1 May 2020

Application by Highways England for an Order Granting Development Consent for the A1 Birtley to Coal House Improvement Scheme (the “Scheme”)
Your reference: TR010031

Northern Gas Networks Limited

Northern Gas Networks Land Ownership

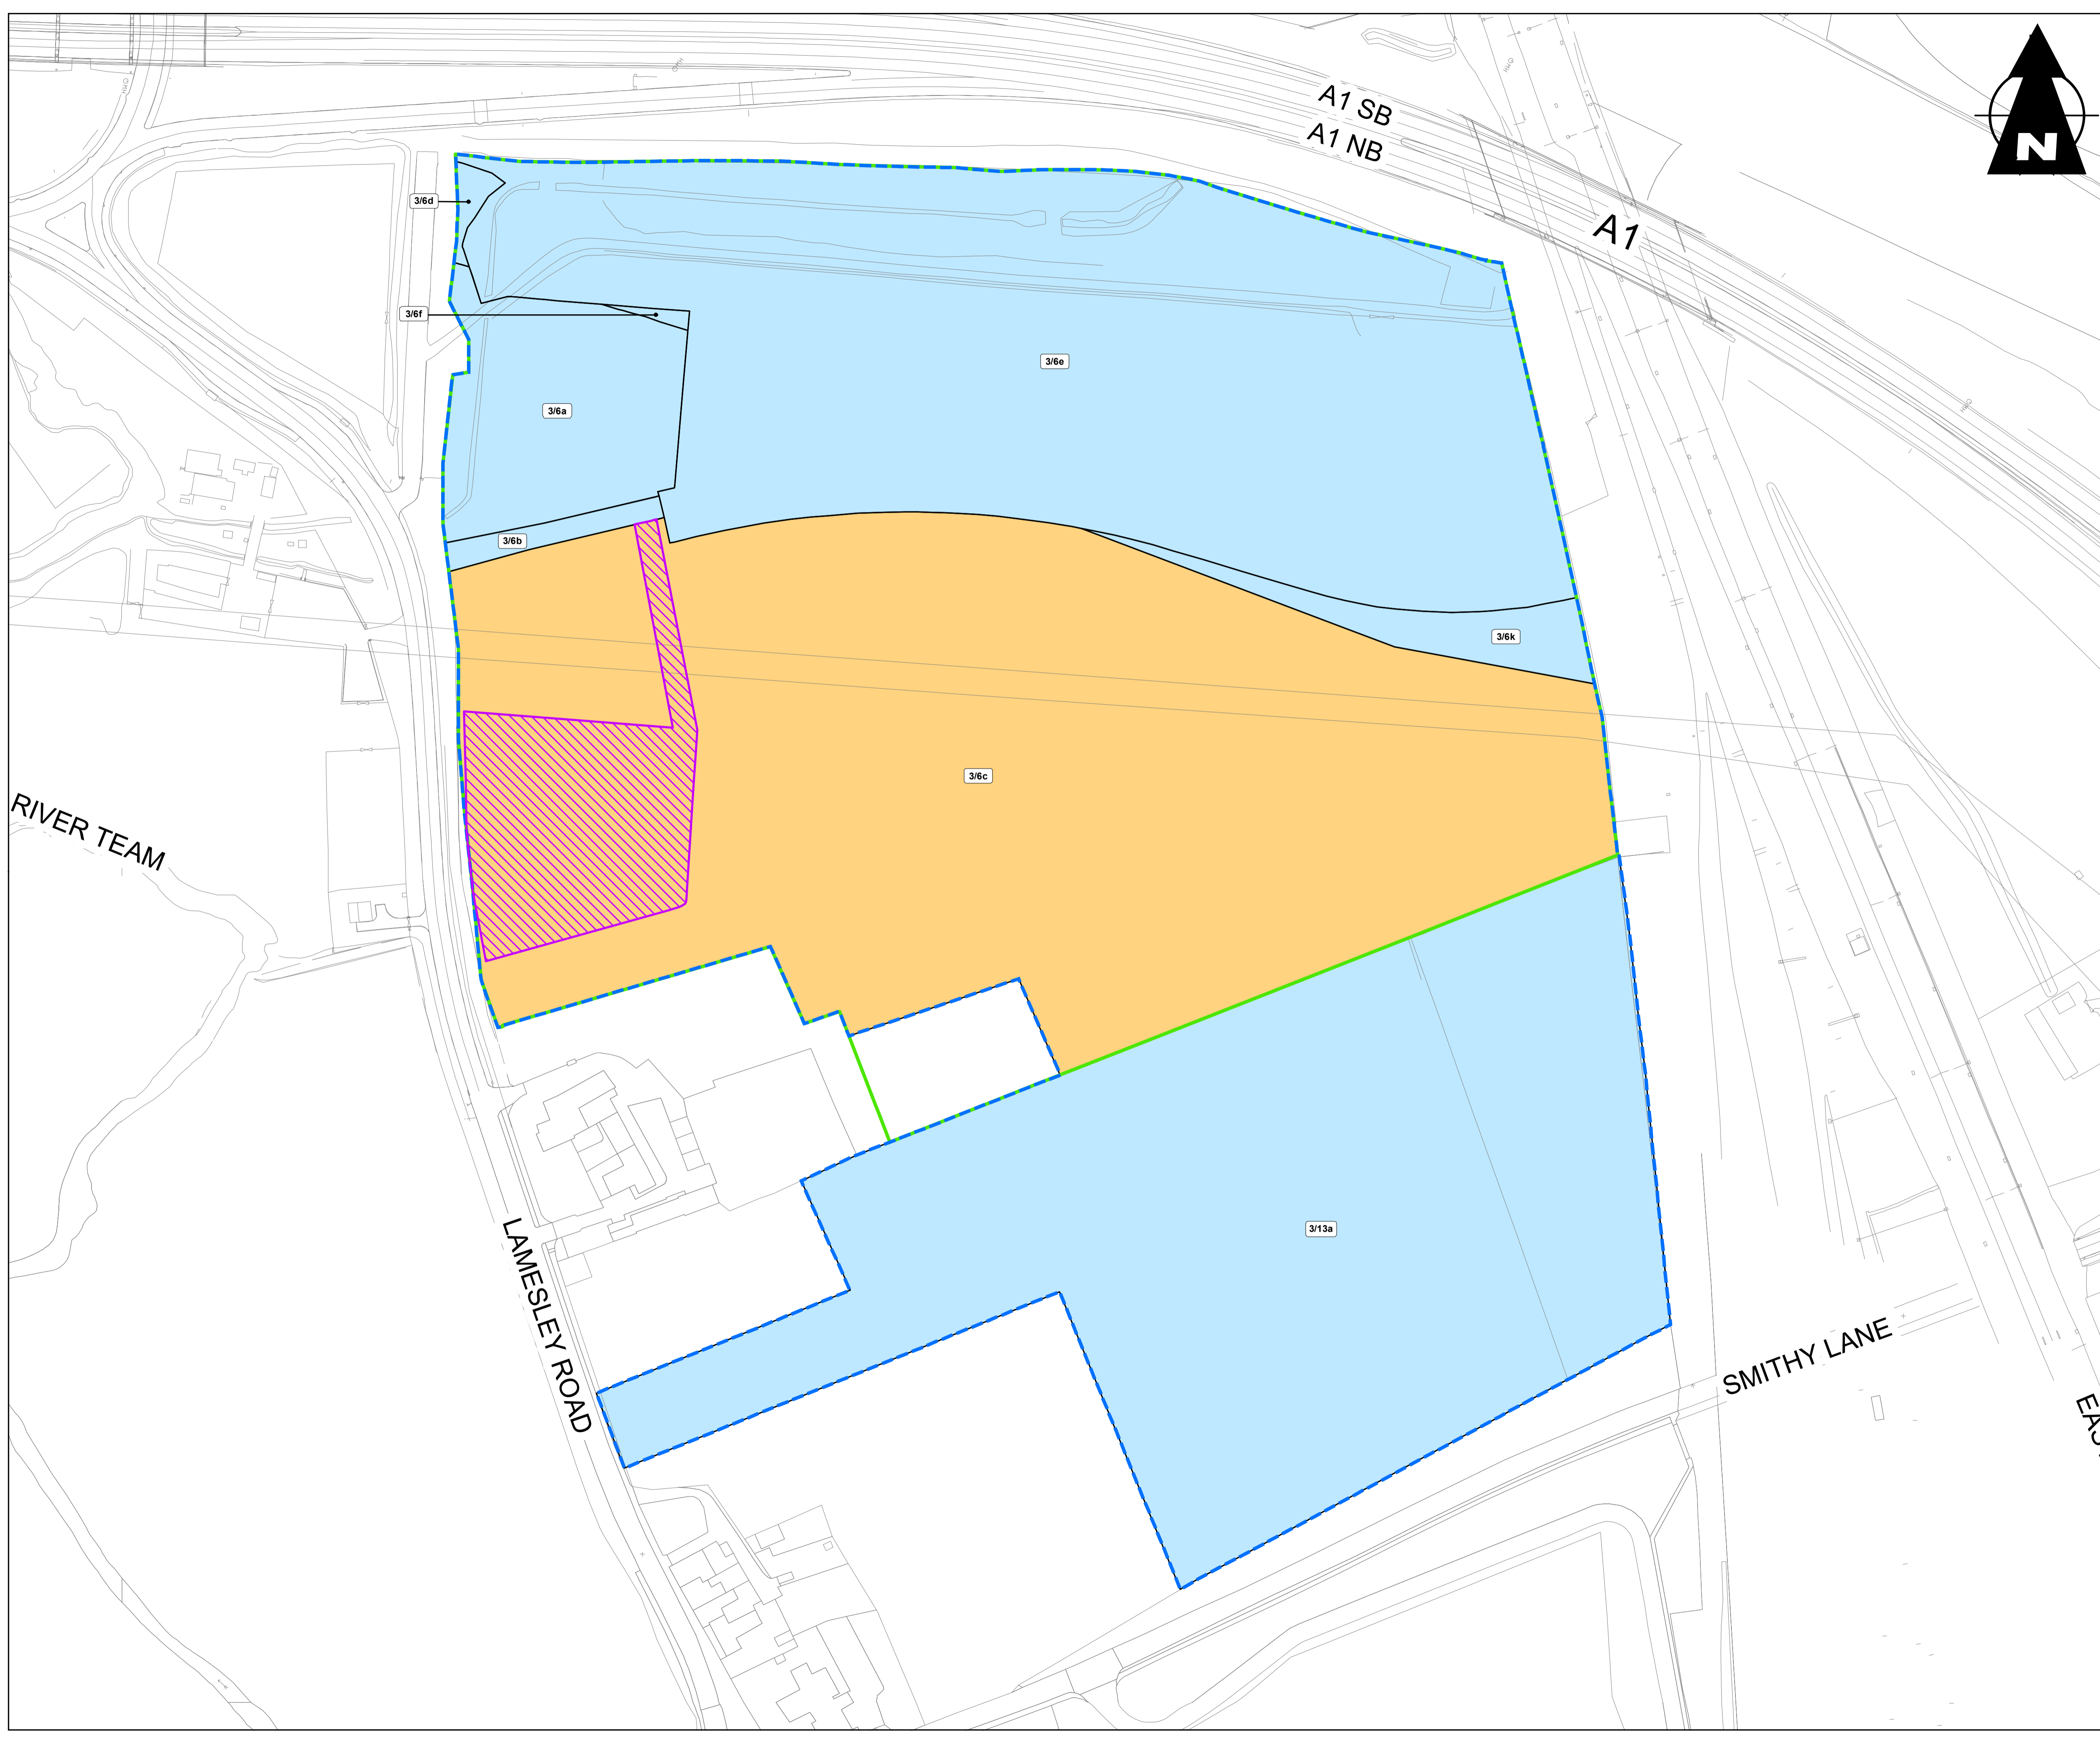
- 3.3 NGN maintain that the land take is excessive and that the Applicant is able to accommodate the CNG Filling Station within the current order limits. As shown on Figure 1, the Applicant has justified the land take by stating that a Staff Car Park will be constructed on the land that NGN seeks to retain. NGN does not accept that that there is a compelling reason as to why a car park should take precedent over the CNG Filling Station which, as previously discussed, will deliver numerous economic and environmental benefits to the area and wider transport network. This failure is even more significant given that this plot is one of the very few sites suitable for a CNG Filling Station, as previously discussed.

- 3.4 NGN also does not accept that the site layout provided in Figure 1 of the updated CEMP provides an accurate representation of the construction compound. As has previously been submitted, there are overhead lines running across the site which, by their nature, will impact the works able to be carried out on the land underneath. We do not believe that Plant, Material and Subcontract stores will be workable in this area, as the height of the overhead lines will restrict movement and the ability for vehicles to be able to pass safely underneath and within the exclusion zone of the lines.

- 3.5 NGN is therefore not in a position to accept the Applicant's justification of the temporary acquisition of Plot 3/6c and invites the Applicant to provide a workable construction compound layout, including a justification presenting a compelling case in the public interest for acquiring the land, in light of the proposed CNG Filling Station. If the Applicant is unable to do this, there is no legal or policy basis for the compulsory acquisition of plot 3/6c.
